Town & Country Planning Act 1990 (as amended)
Town and Country Planning (Development Management Procedure) (England) Order 2015
Application for approval of details reserved by condition imposed under planning permission
FG/5/18/PL relating to condition No. 3 - Details of parking space including materials
9 St Malo Court St Helier Road, Ferring,

Condition Number 3

Arun District Council have decided to **REFUSE details reserved by condition for the following reasons:**

9 St. Malo Court, St. Helier Road, Ferring, Worthing, BN12 5EY

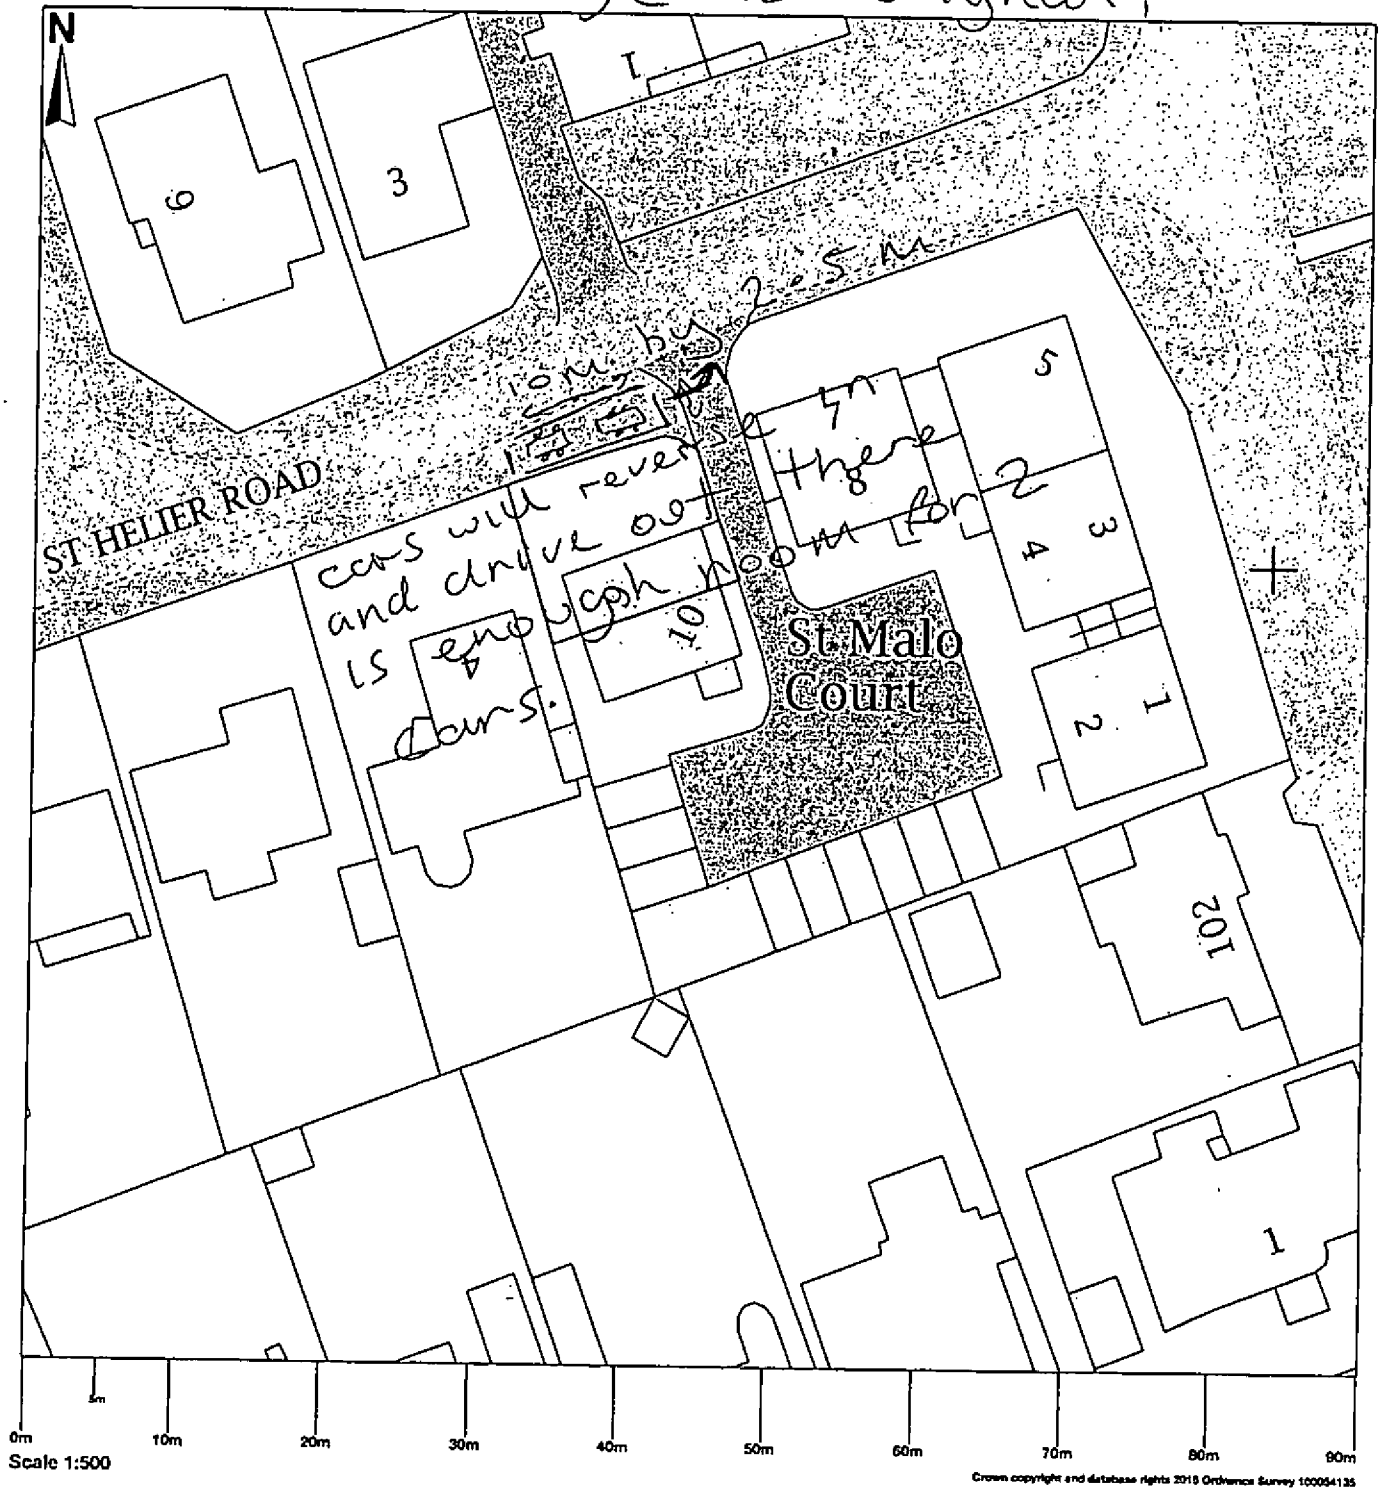
This condition cannot be discharged. Precise details of the reinforced mesh have not been submitted. Accurate and detailed drawings and sections of the parking space and the extent of surfacing are required.
